Peartree Hill Solar Farm

Environmental Statement Addendum Revision 2

Application Document Ref: EN010157/APP/8.2

August 2025

TITLE: Figure 2:
VP Locations and Transect Routes

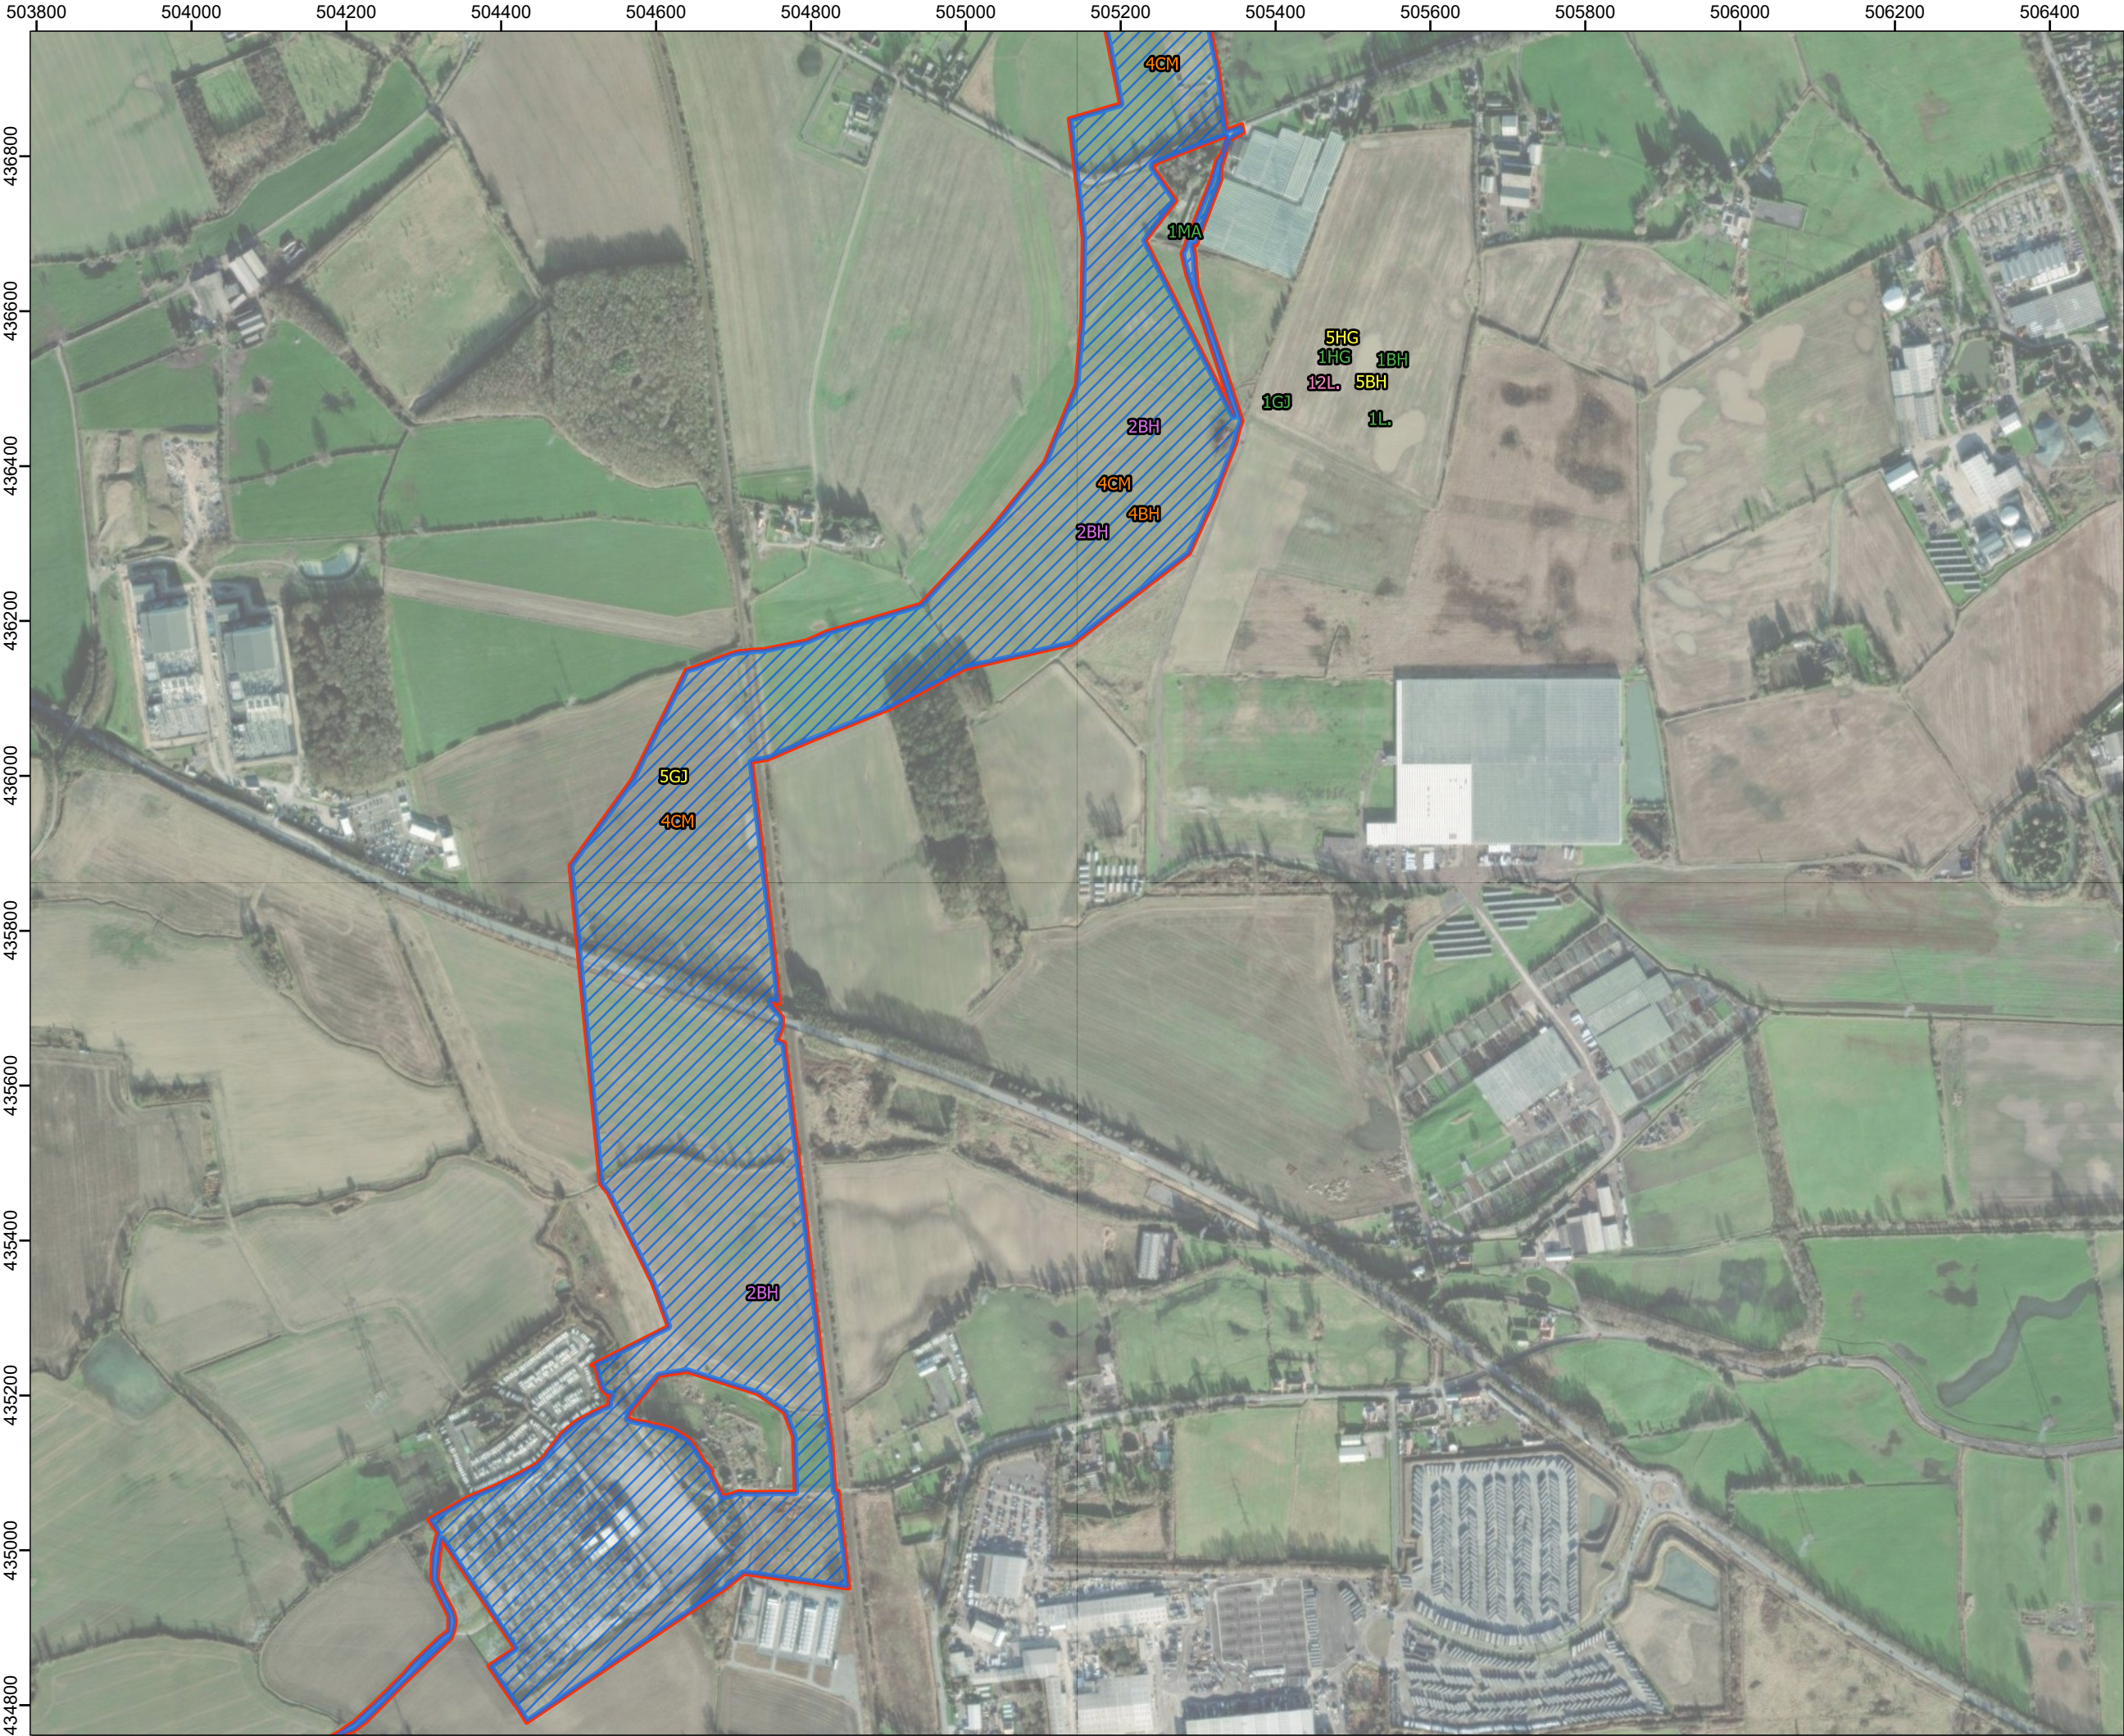
ES Volume 2, Chapter 7: Biodiversity [APP-043]	<p>Response to Natural England’s relevant representations [RR-012] (NE7 and NE8a) to consider the Humber Estuary Site of Special Scientific Interest (SSSI) within the assessment and to amend details of pre-construction water vole and otter surveys in line with appropriate guidance</p> <p>Updated to cross-reference or incorporate changes from and ensure consistency with the following new or updated documents:</p>	<p>ES Chapter 7 is amended in response to Natural England’s representations and to align with other updated documents.</p> <p>Resubmitted on 27 August 2025 as: ES Volume 2, Chapter 7: Biodiversity – Rev 2 (clean)</p> <p>ES Volume 2, Chapter 7: Biodiversity – Rev 2 (tracked)</p>

Figure 1-1 Regional Context

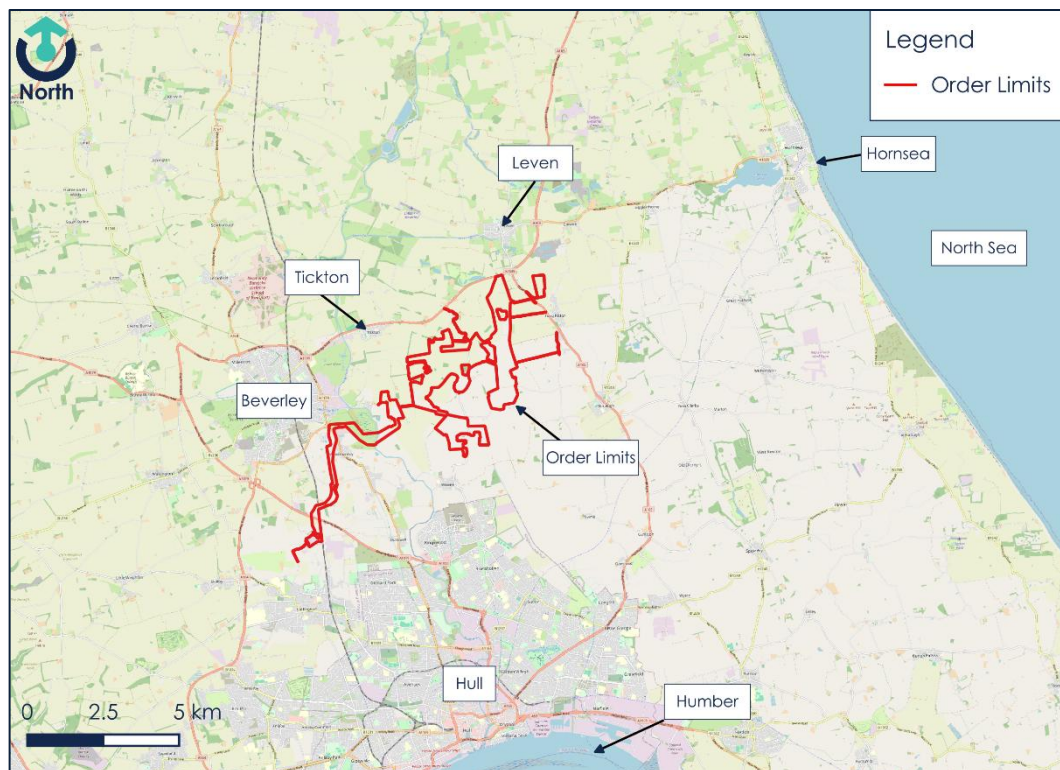
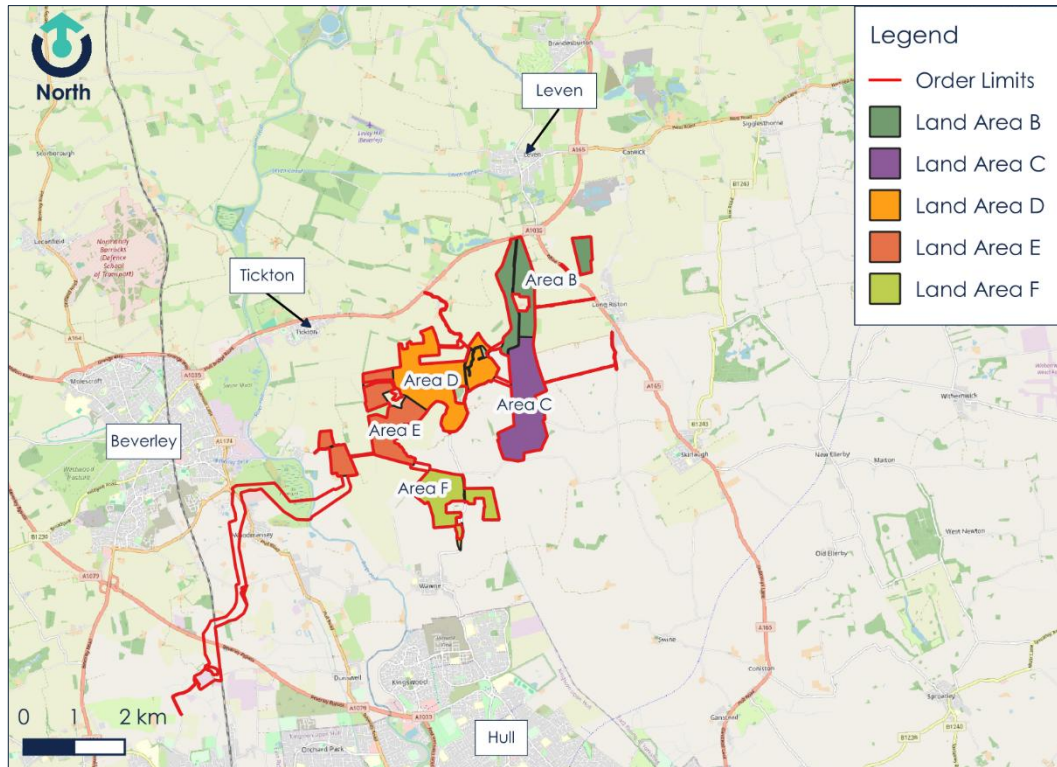
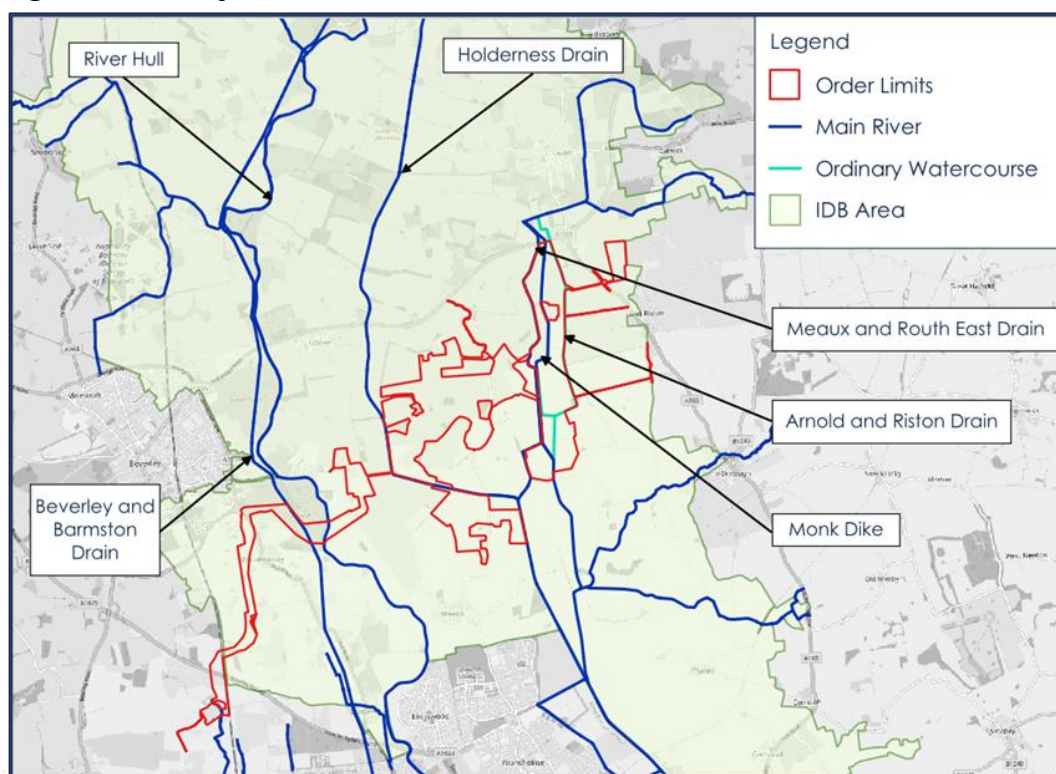
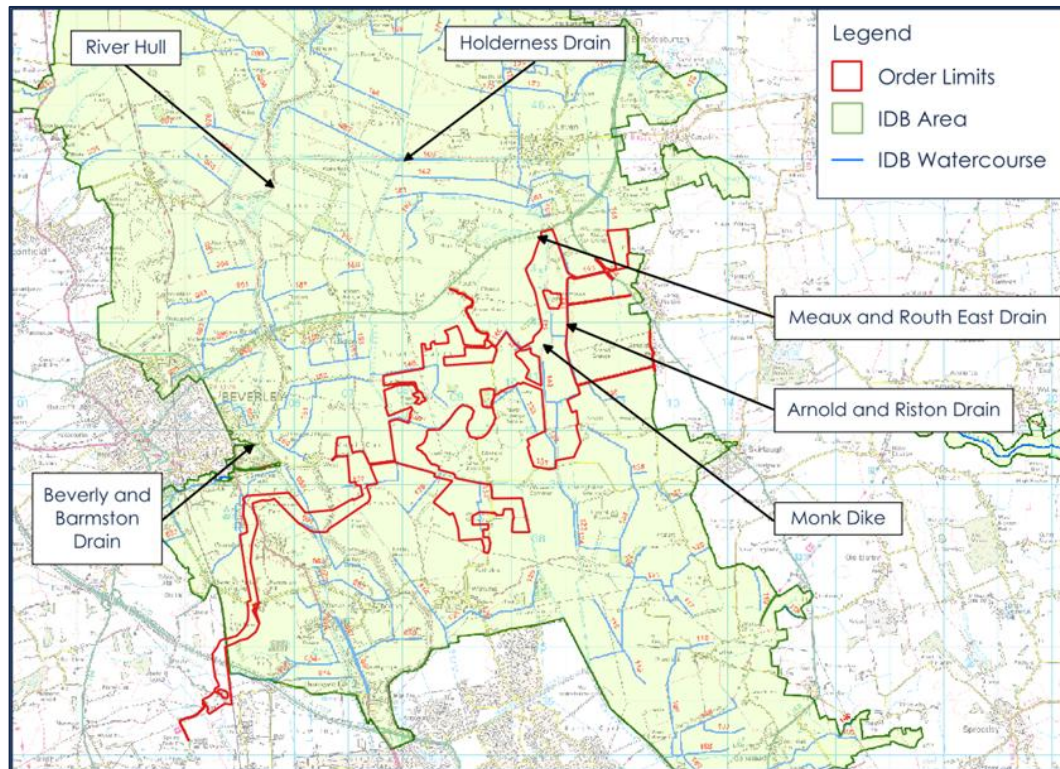
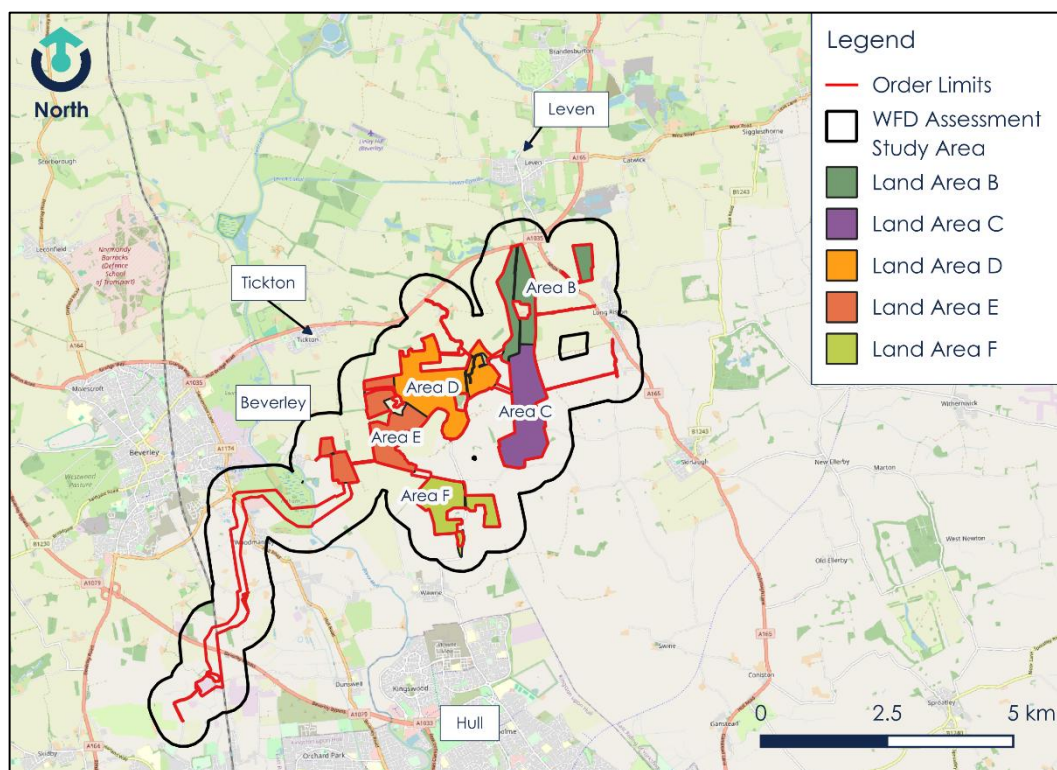
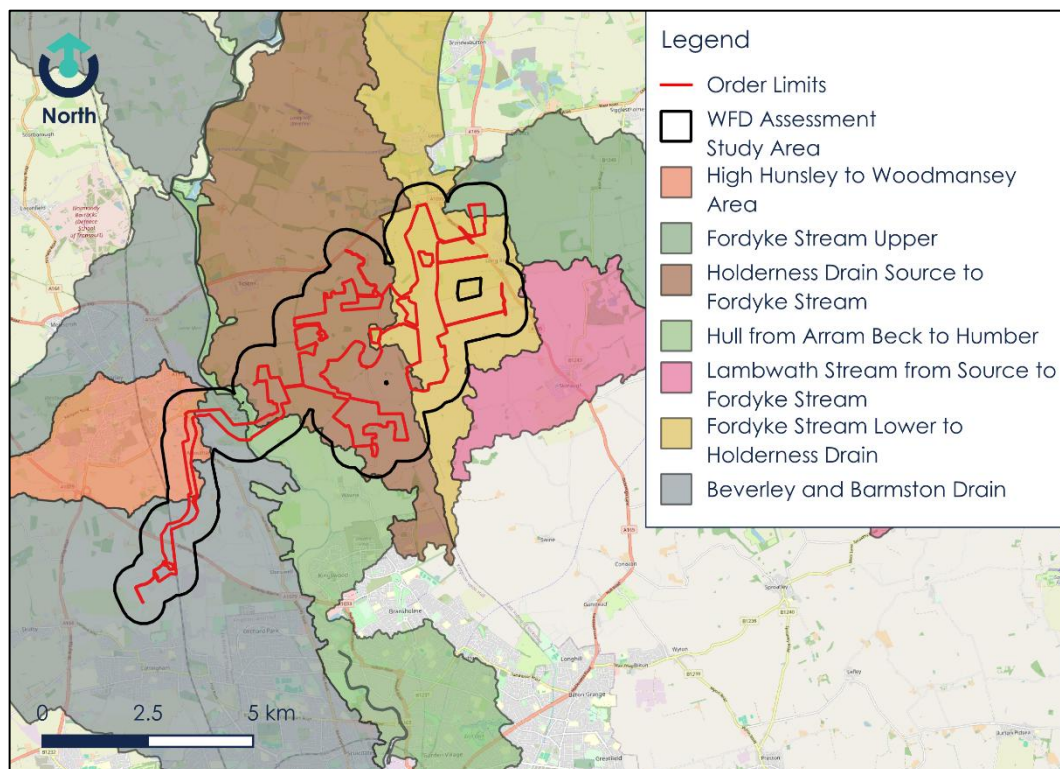
Document reference	Reason for amendment	ES Amendment August 2025
ES Volume 4, Appendix 5.5: Water Framework Directive Screening and Scoping Report [APP-101]	Response to relevant representations from Beverley and North Holderness Internal Drainage Board [RR-004] and the Environment Agency [RR-005] (EA04, EA06, EA07, EA10, EA20 and EA24).	ES Appendix 5.5 is amended to include additional assessment of battery fire effluent risks; to refine or clarify the Applicant's approach in relation to land drains and watercourse crossings; to provide further details on cable crossings and dewatering; and to provide further information regarding surfacing of access tracks and update the surface water drainage strategy reflecting discussions with Beverley and North Holderness Internal Drainage Board. Where new paragraphs have been added, subsequent paragraphs are automatically renumbered. Resubmitted on 27 August 2025 as:
